**KIRKLEES METROPOLITAN COUNCIL  
INVESTMENT & REGENERATION SERVICE**

**DELEGATED DECISION TO DETERMINE PLANNING APPLICATIONS**

Reference No:	<b>2023/62/91577/E</b>
Site Address:	14, Thornhill Park Avenue, Thornhill, Dewsbury, WF12 0DA
Description:	Erection of detached dwelling
Recommending Officer:	Nina Sayers

**DECISION - REFUSE**

PROPOSED GROUND FLOOR
1:50

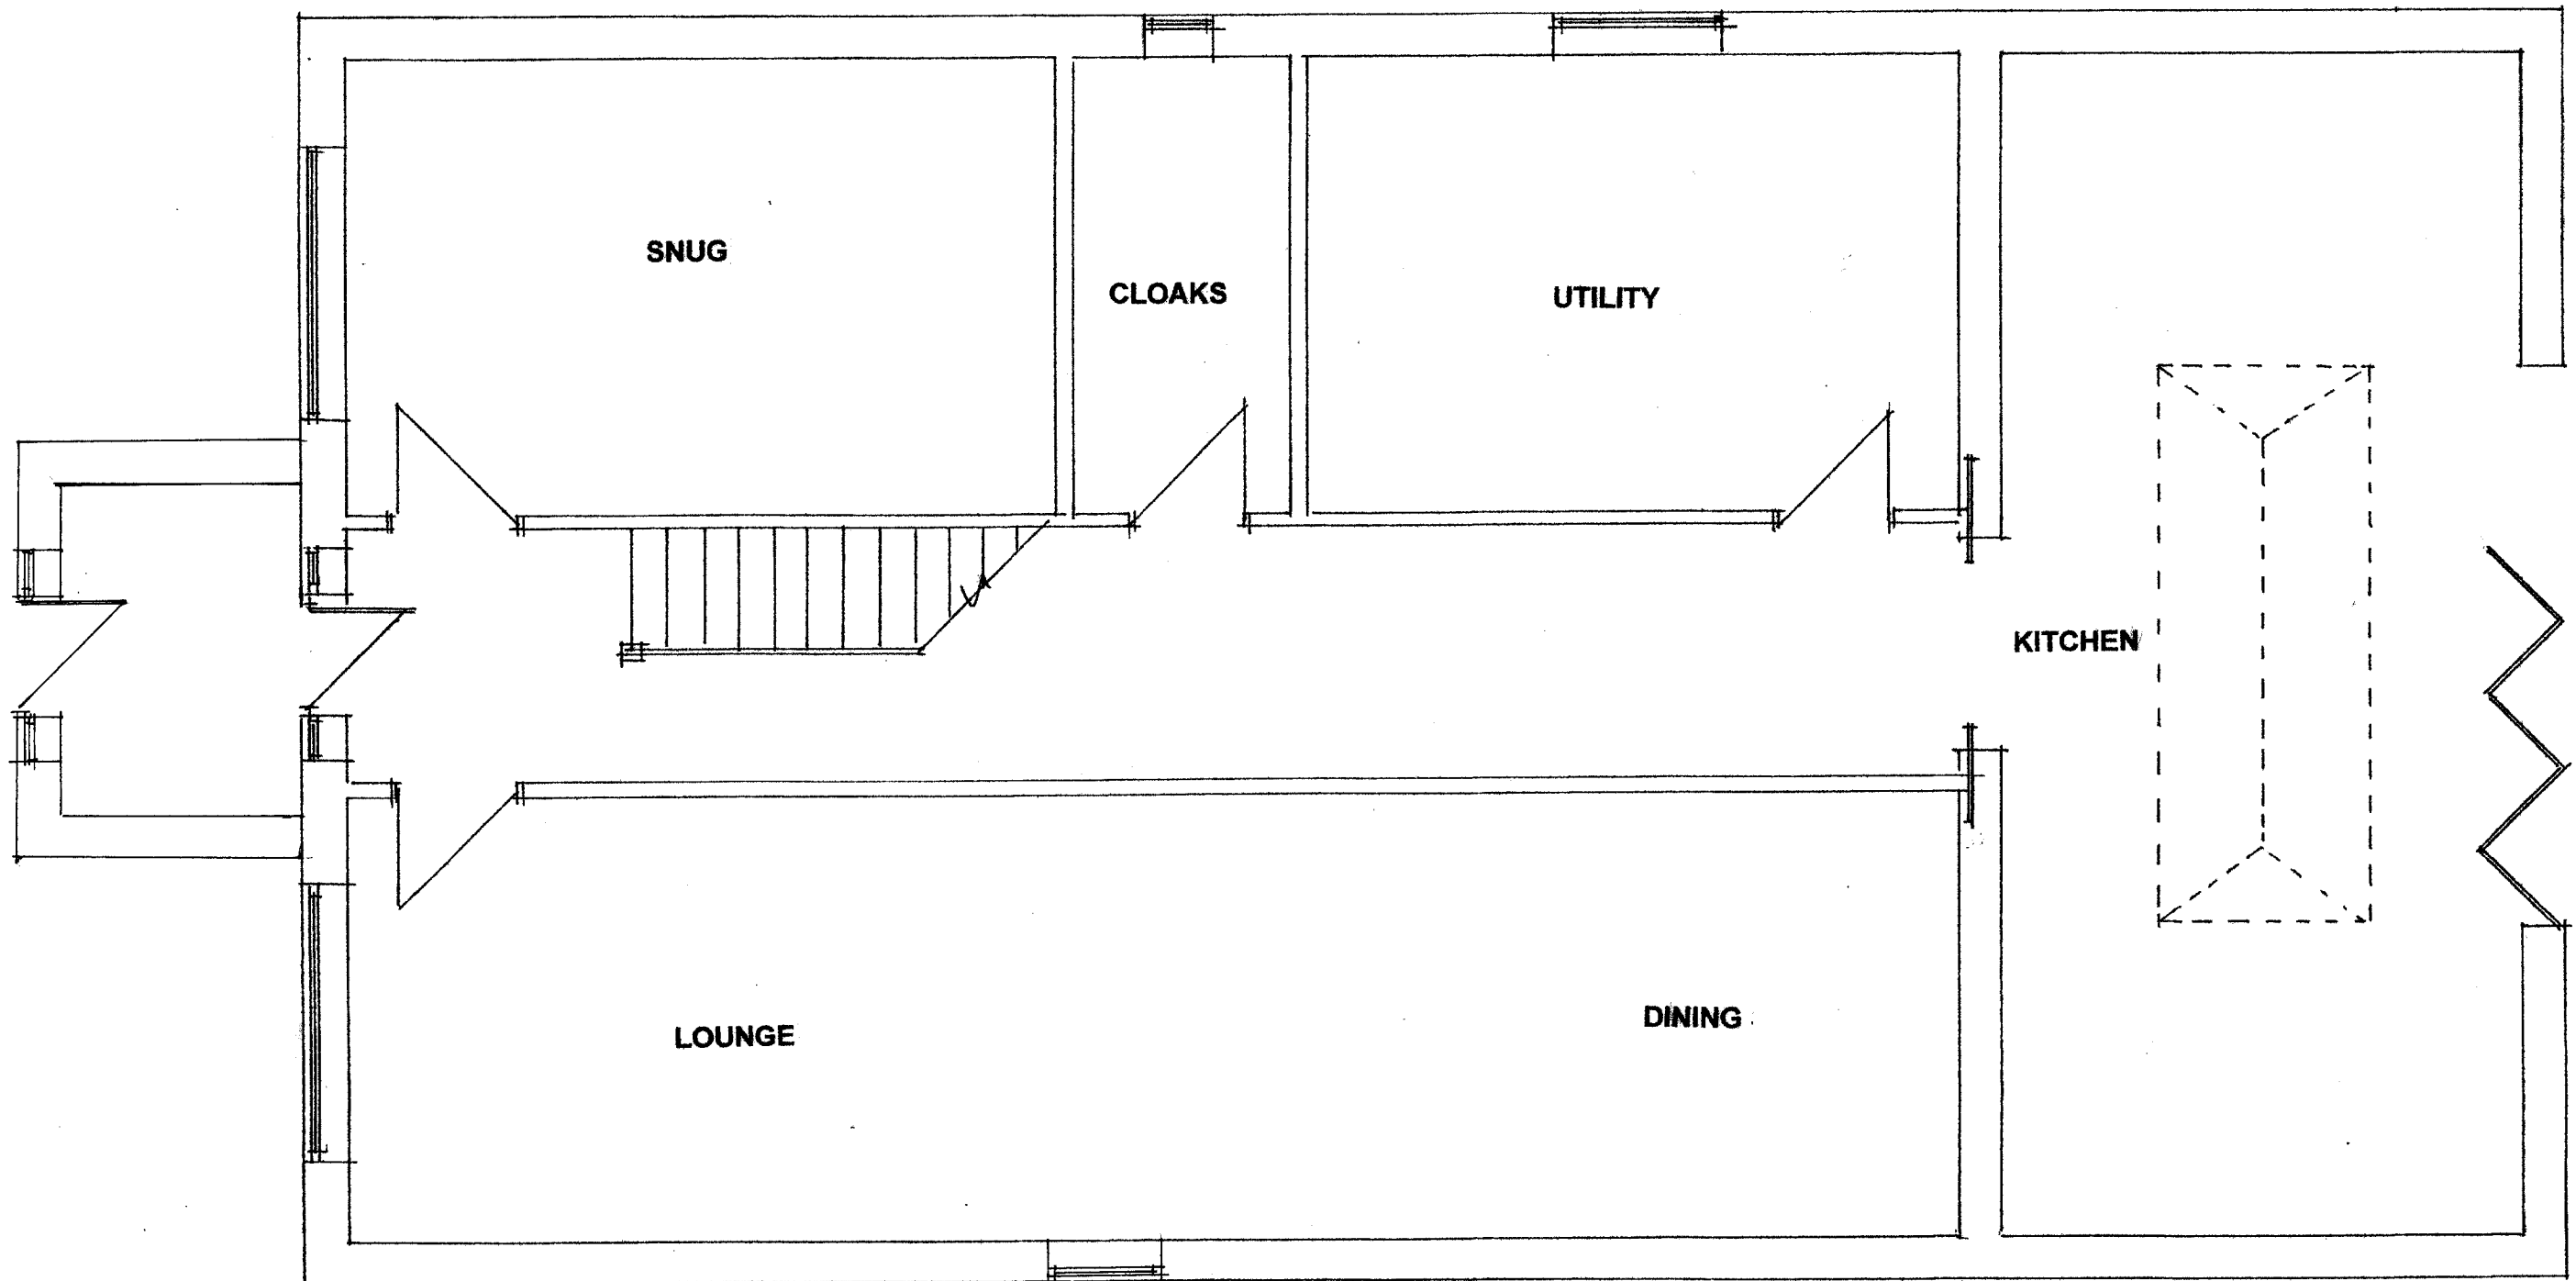
- 10.20 The proposed dwelling would be entirely covered in hardstanding to the front and rear. It is noted there is a grassed raised platforms erected to the rear of the dwelling; however, this has not been included as part of the current application and requires planning permission as this would be considered an engineering operation. The applicant has been advised that they should seek permission for this development under a separate application. In the interest of visual amenity, officers would want to see more soft landscaping within the application site. Given the proposed dwelling is considered unacceptable in terms of visual amenity in any case, amended plans were not sought in this instance.

10.29 The proposed dwelling would result in a 12m deep two-storey building with an additional 4m single storey element, which stretches along the full extent of the boundary with no.14a. This would have an oppressive, overbearing and overshadowing impact on the amenity of the occupiers of that dwelling, with specific reference to the openings in the side elevation of no.14a and the primary amenity space. This is further exacerbated by the structure which was being constructed to the east of the dwelling which would be built directly along the only remaining, undeveloped boundary of no.14a. This structure is not being assessed under this application, but it is noted this has been erected without planning permission. The applicant has been advised that they should seek permission for this development under a separate application.

PROPOSED FRONT ELEVATION
1:100

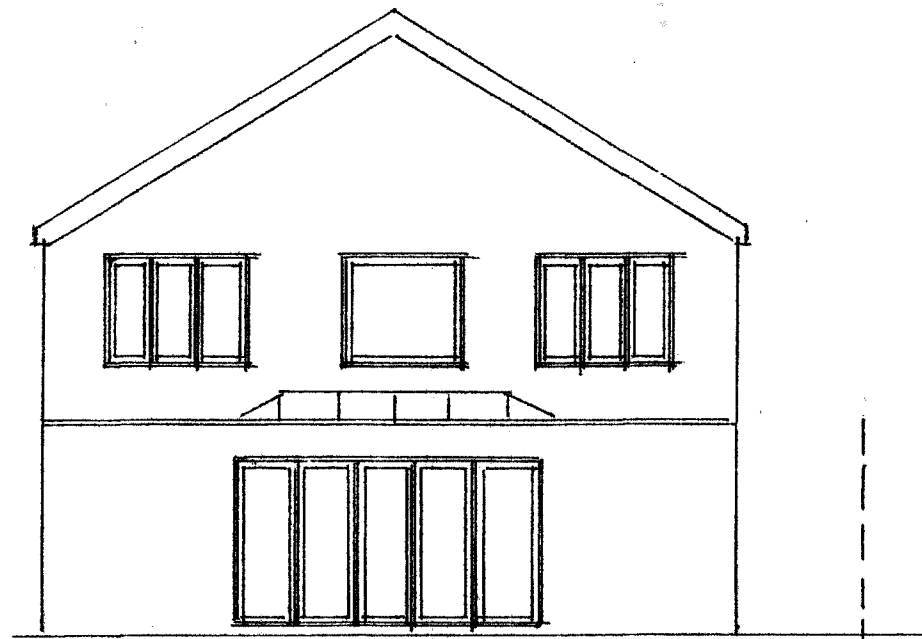
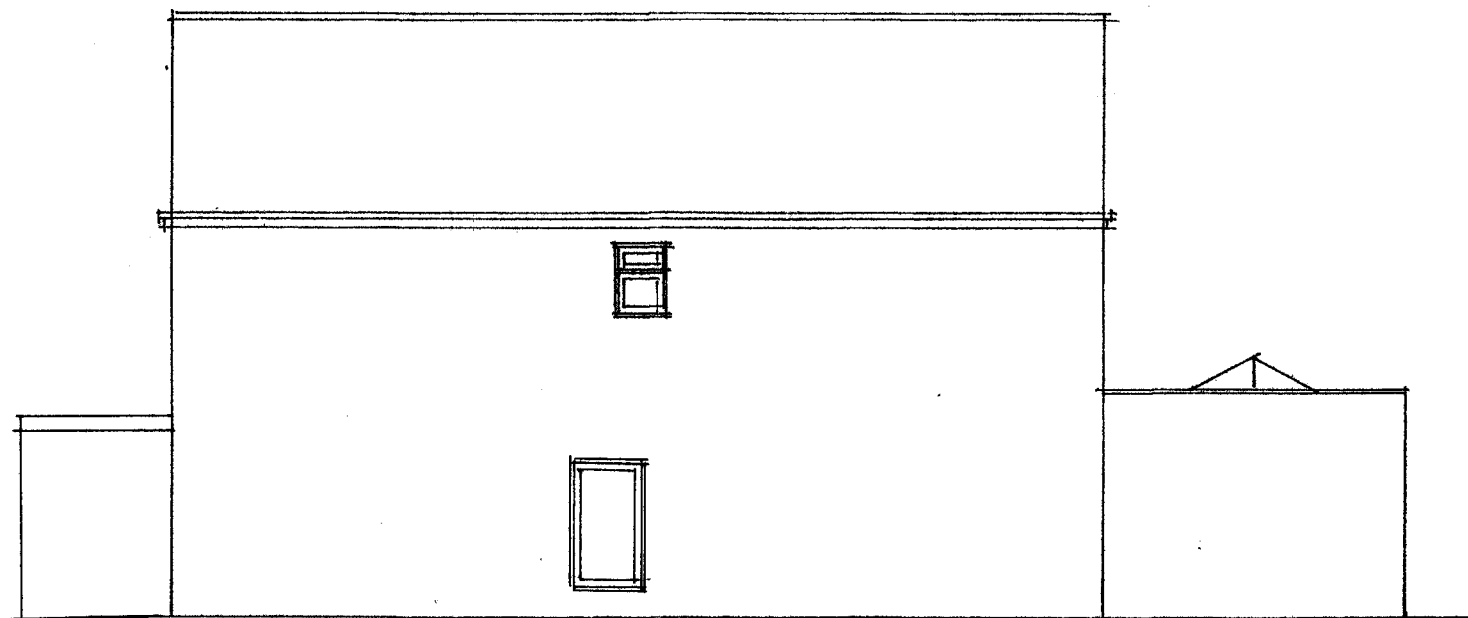
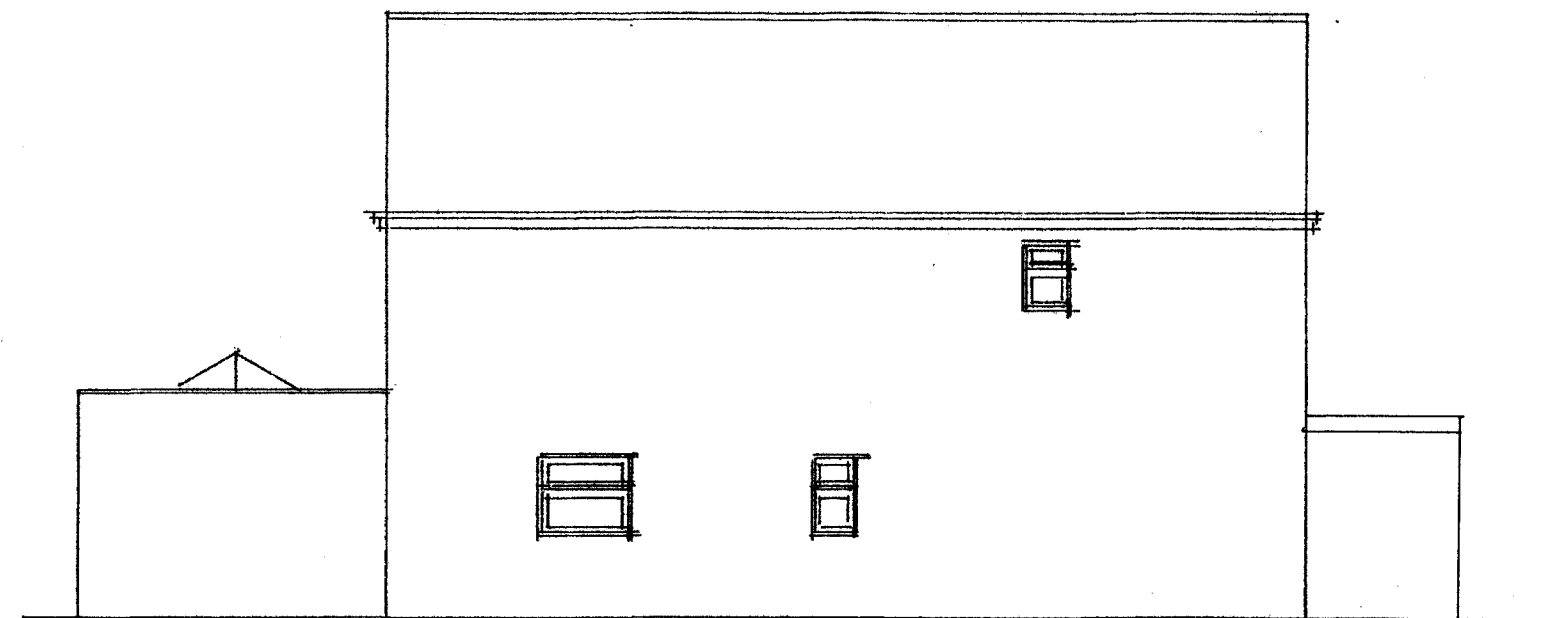
1. The proposed dwelling, by virtue of scale, massing and design, would fail to integrate sympathetically into the street scene and would not be in keeping with the character of the area. The scheme would therefore fail to comply with Policy LP24(a) of the Kirklees Local Plan, Principle 2 of the Housebuilders Design Guide SPD and the aims of chapter 12 of the National Planning Policy Framework.

10.17 The scale and massing of the proposed structure would be significantly larger than the other dwellings in the estate and would not be in keeping with the local character of the area, thus failing to comply with Policy LP24(a) of the KLP and Principle 2 of the Housebuilders Design Guide SPD.
